Rezoning Transportation Analysis

Petition Number: 2020-015

Revision Log:	Date	Description
	02-16-2020	First Review
	03-25-2020	Second Review

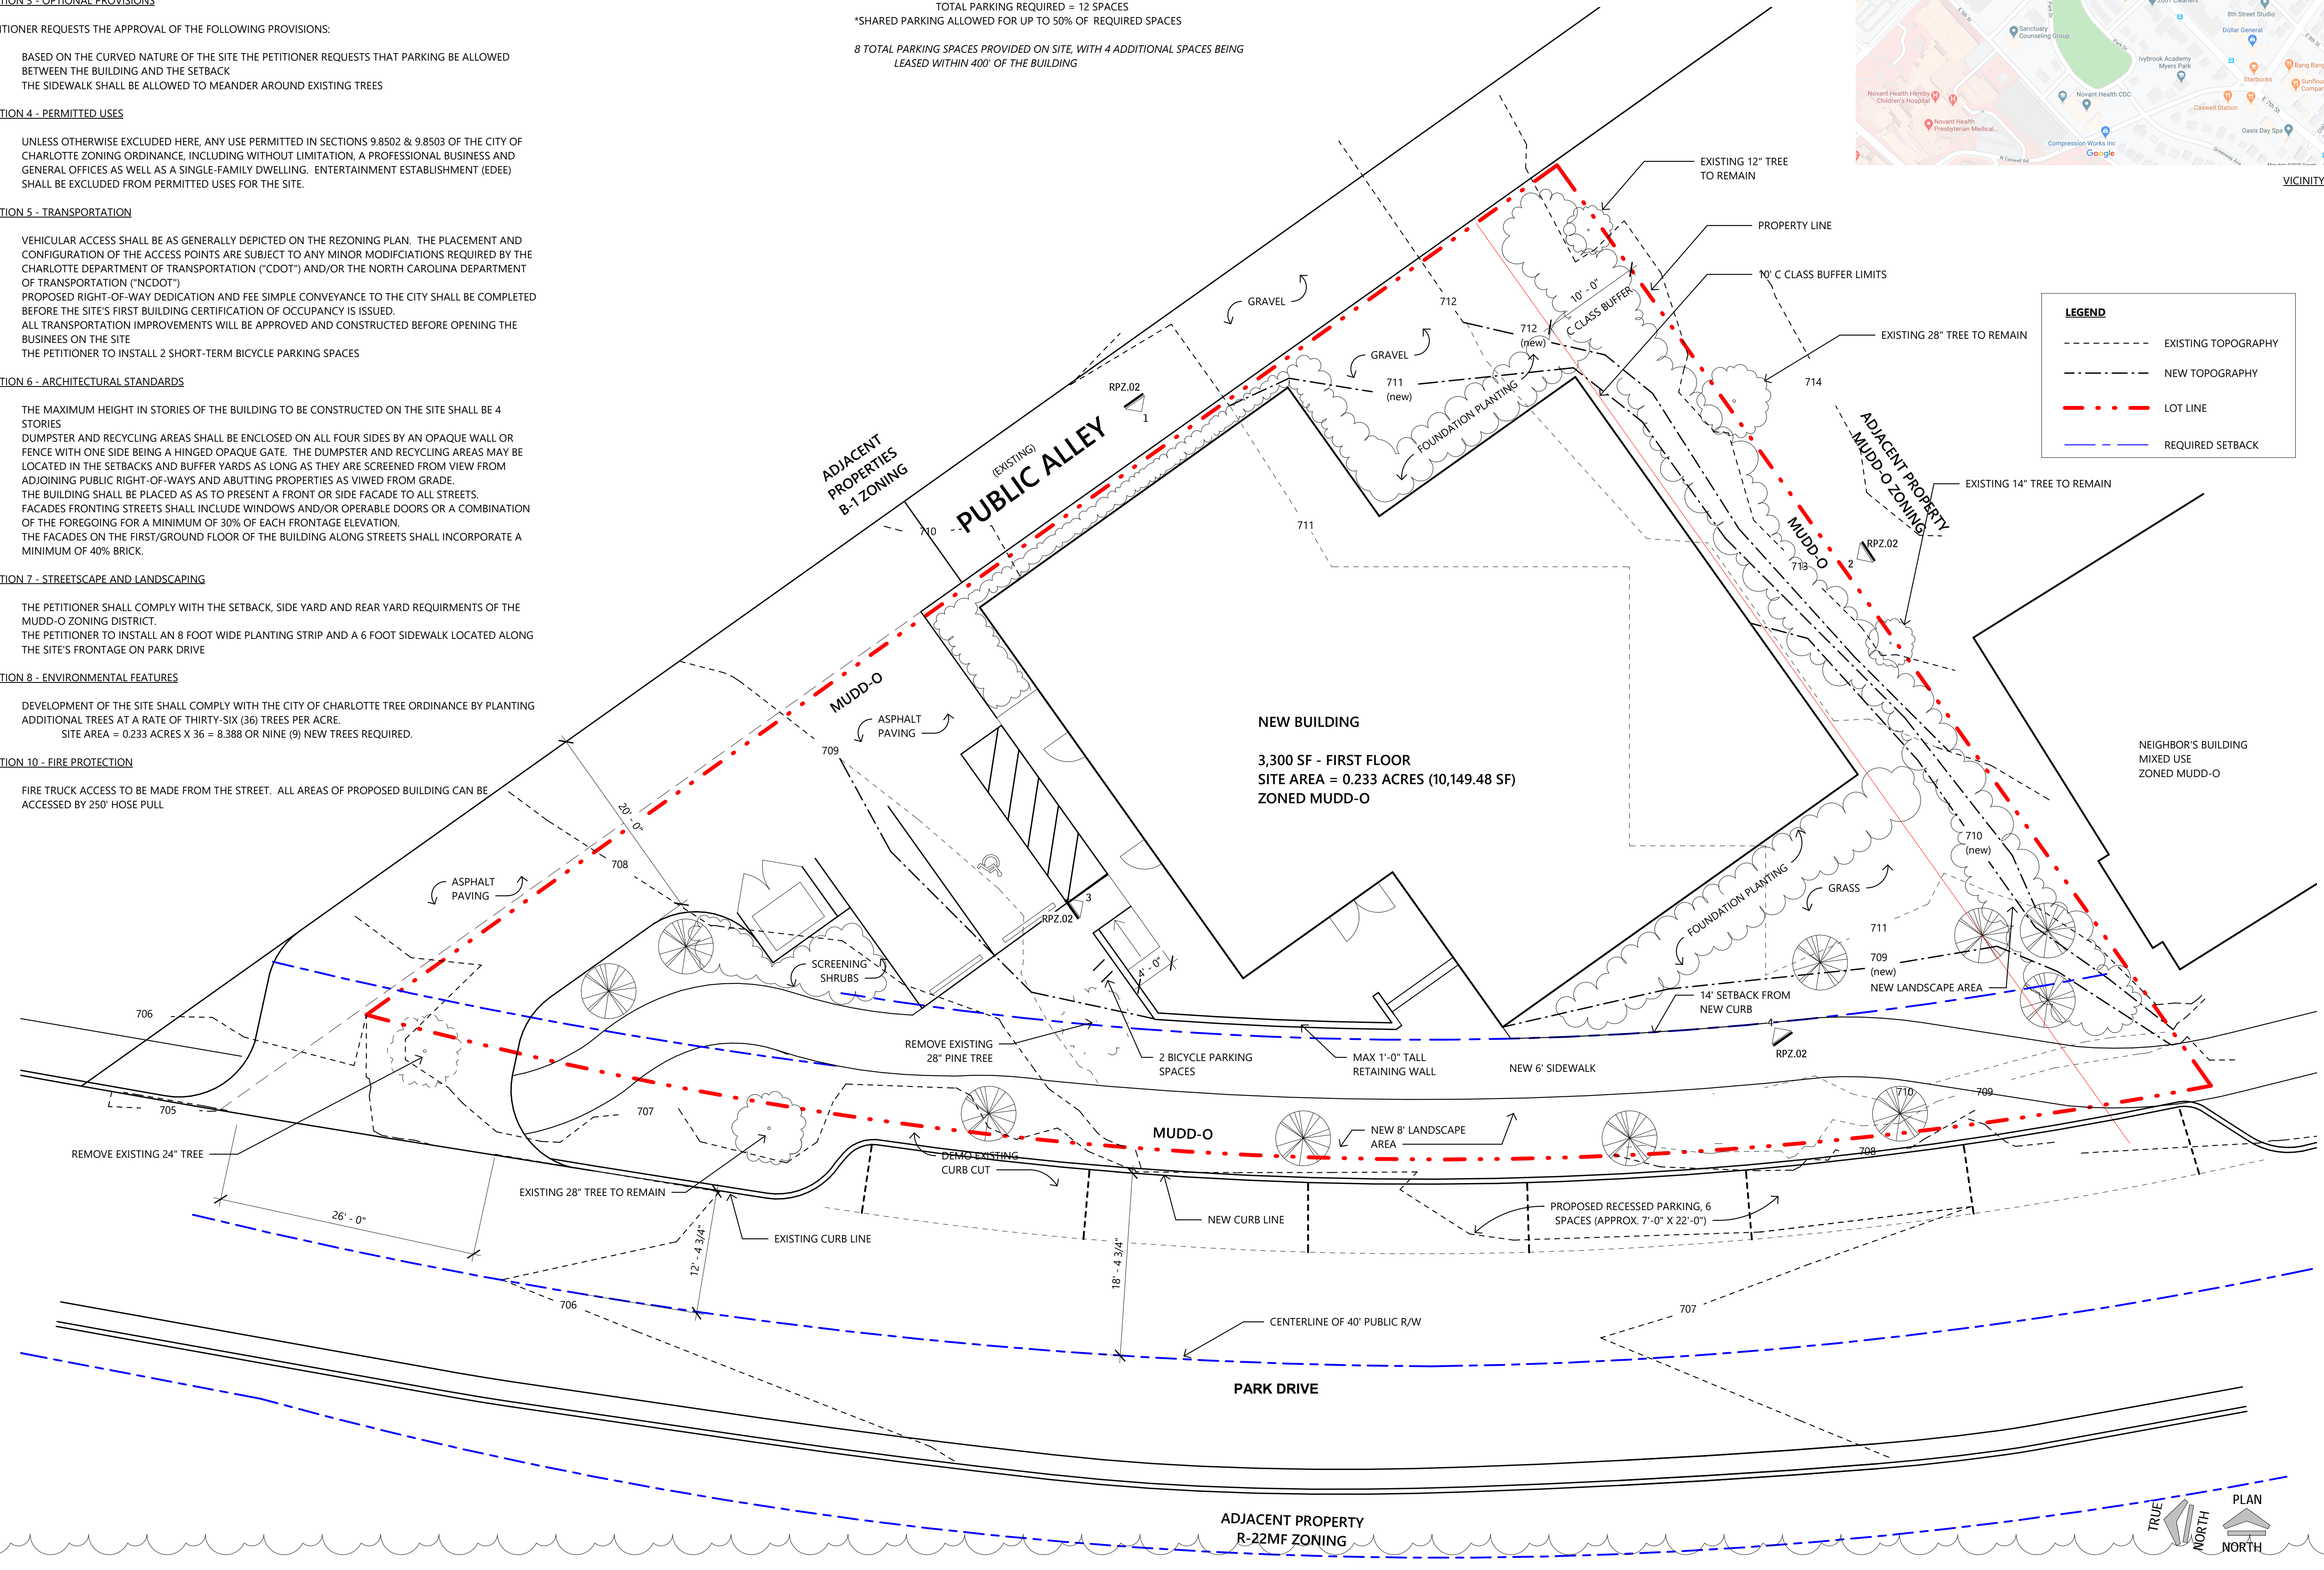
1. **Curbline** The proposed zoning district has a setback measured from back of the existing or proposed future curbline.
 - a. **Park Drive:** The future location of curb and gutter is in its existing location.

The site plan should show the curb and gutter labeled and dimensioned from the centerline for each road.
